**DEVELOPMENT FACILITATIVE TEAM (DFT)**  
**Code Enforcement Comments**

**PR-2023-009382**

**SI-2024-00739 – SITE PLAN DFT**

**REQUEST:** FBT requests approval of DFT package for permit for Cibola Loop Multigenerational Facility

City Project No. P7882.16
 Zone Map No. A-13-Z
 DWG. AS-101
 Sheet

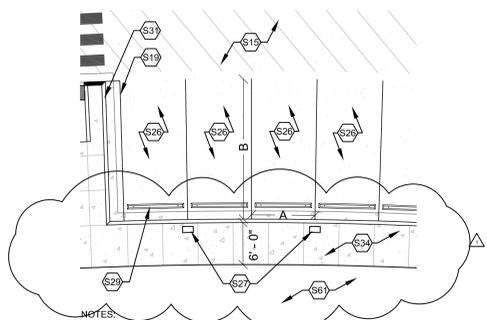
Please articulate how the project meets this code.

FBT Response: The closest portion of the building to the property line is 154'-8". No part of the building is closer than 100' to the nearest residential unit. The 30' height restriction therefore does not apply. See sheet AS-101, included in this DFT submittal.
